Request for Information 1, 7833 SE 28th St--revised
Project #DSR20-010 & SEP20-005

Per the comment letter dated February 16, 2021, below is the response to this comment letter along with the revised and updated plan set.

Sheet Title
SITE LIGHTING PLAN

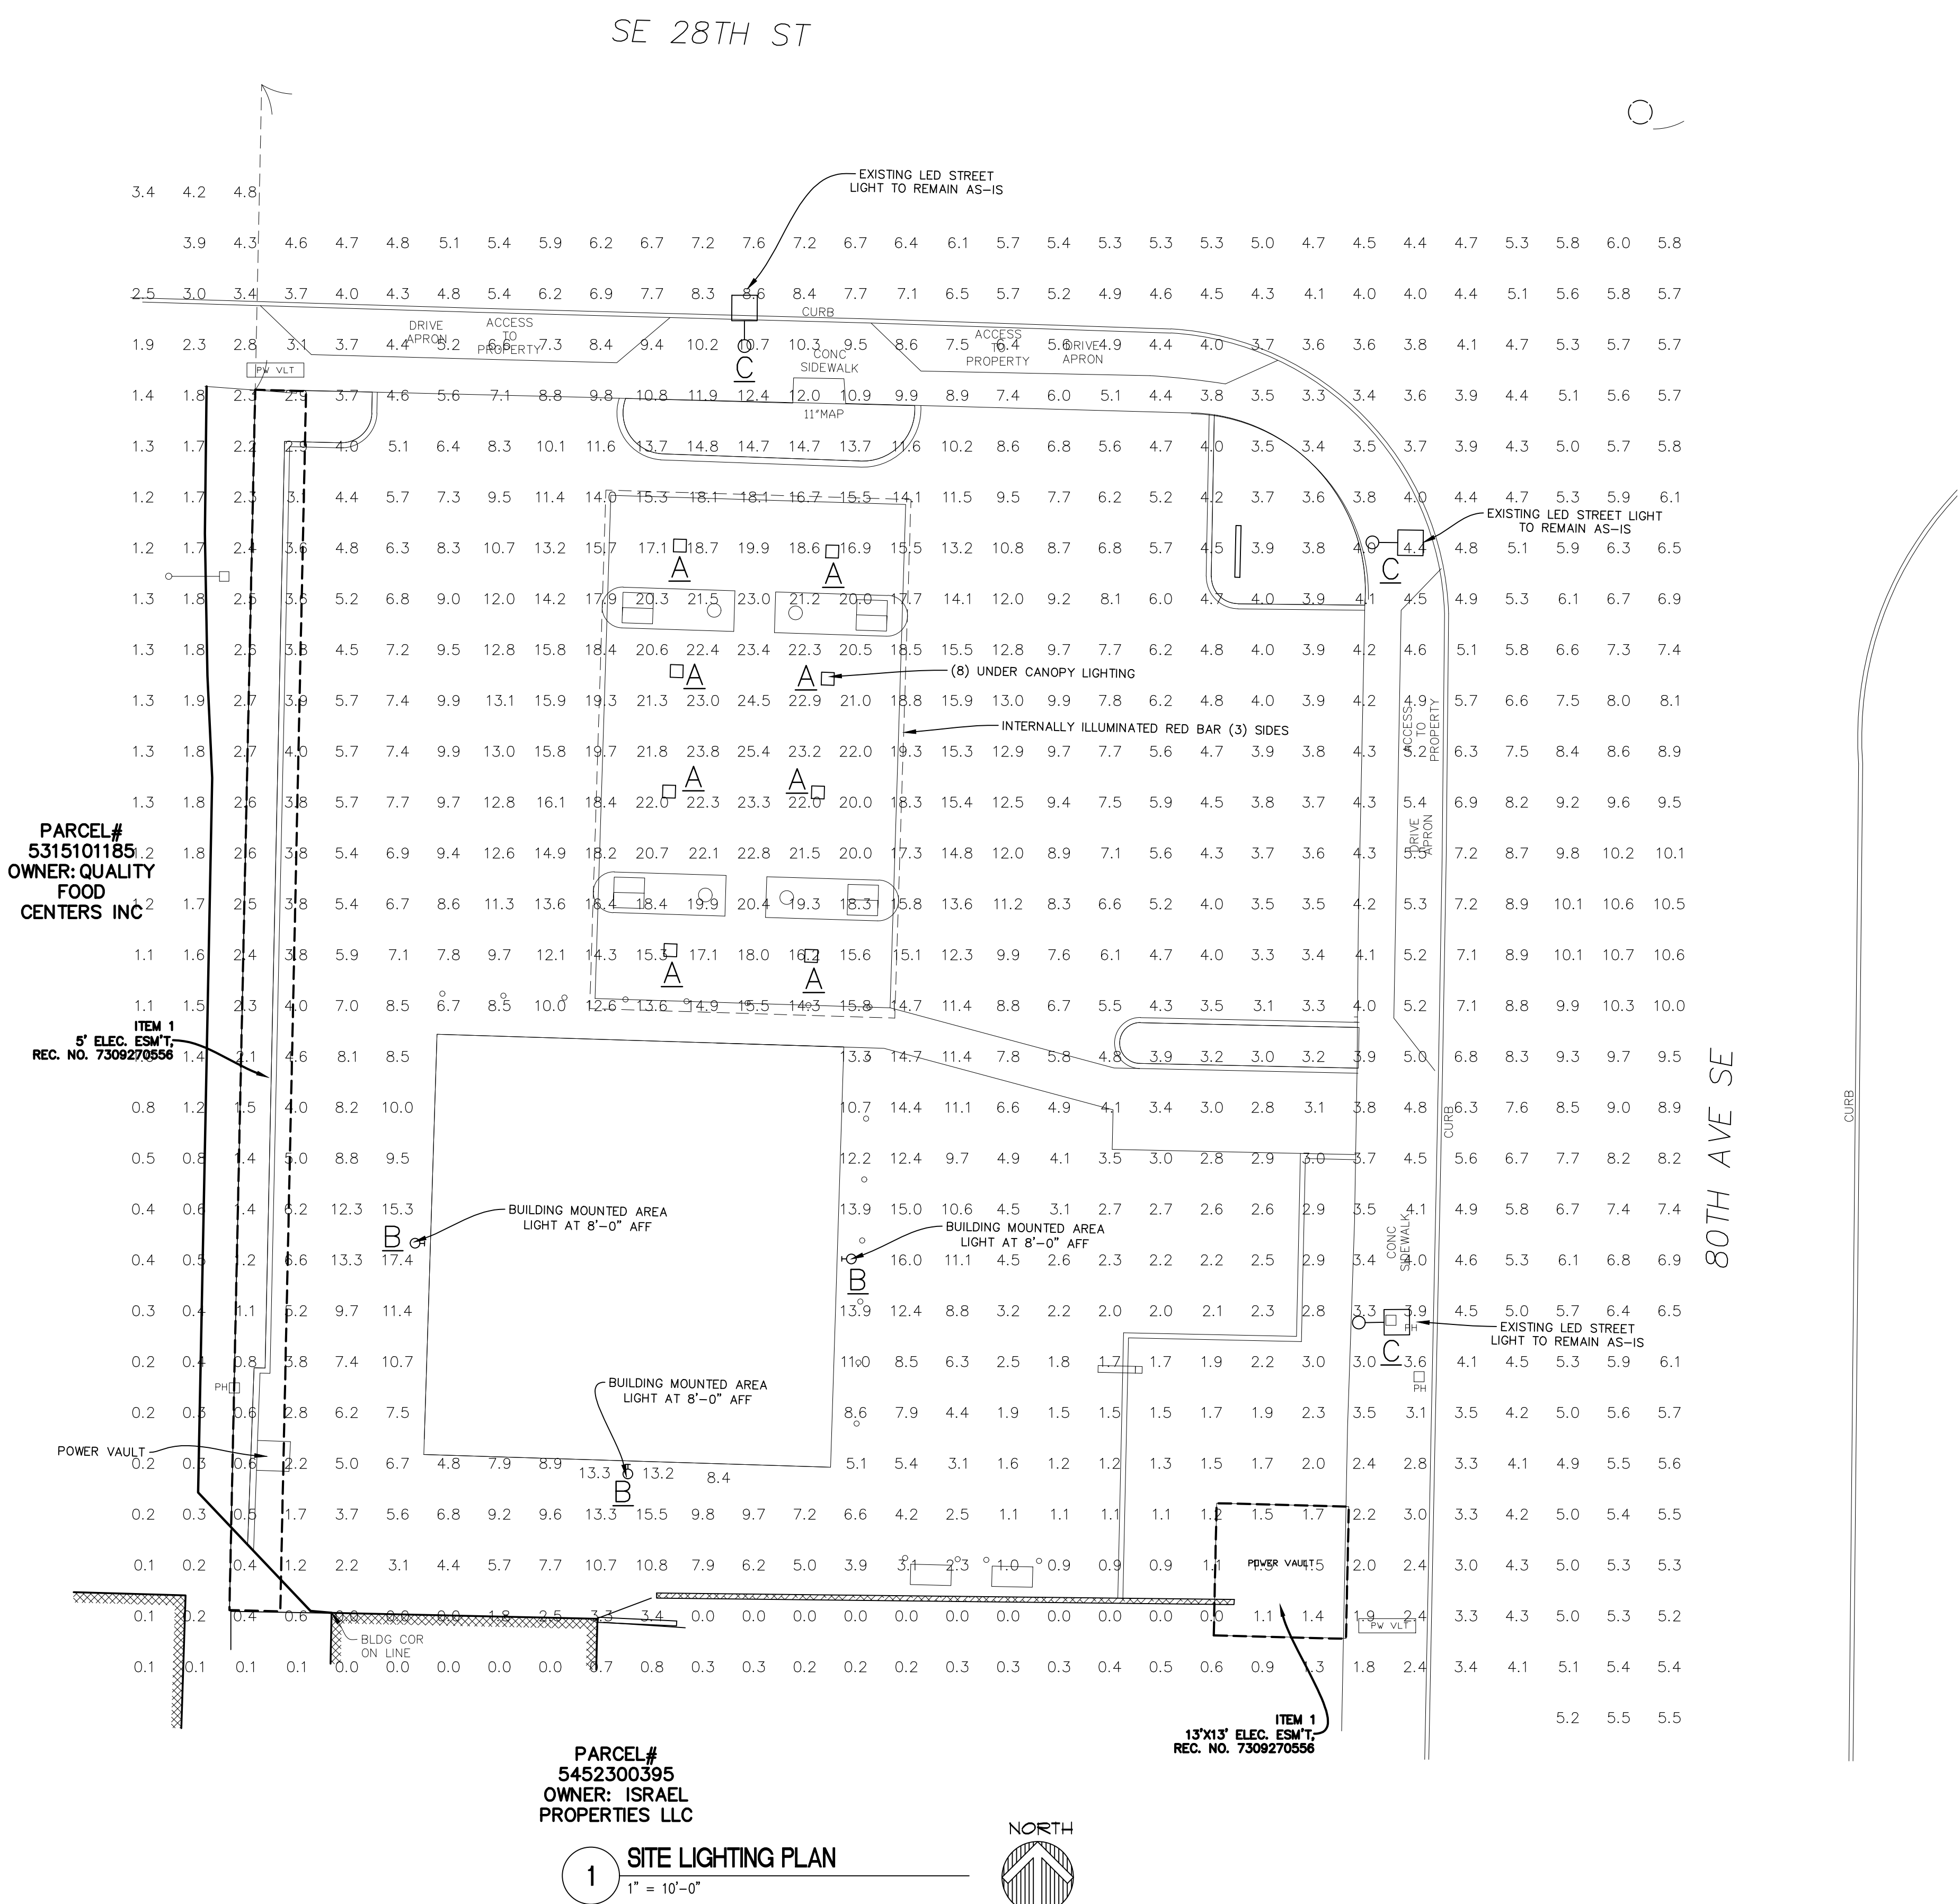
1. Please provide information about the proposed lighting for the store and fuel canopy, documenting how the standards in MICC 19.11.090 are met. These include standards requiring pedestrian-scale light fixtures, the use of LED or similar minimum wattage light sources, the use of light shielding, and limited use of neon lighting.

- a. A site lighting plan has been provided. See attached. Site lighting consists of recessed fuel canopy lighting and building lighting. The building lighting is small wall packs that are shielded and located at 8'-0" above ground. All lighting is LED. No neon is used.
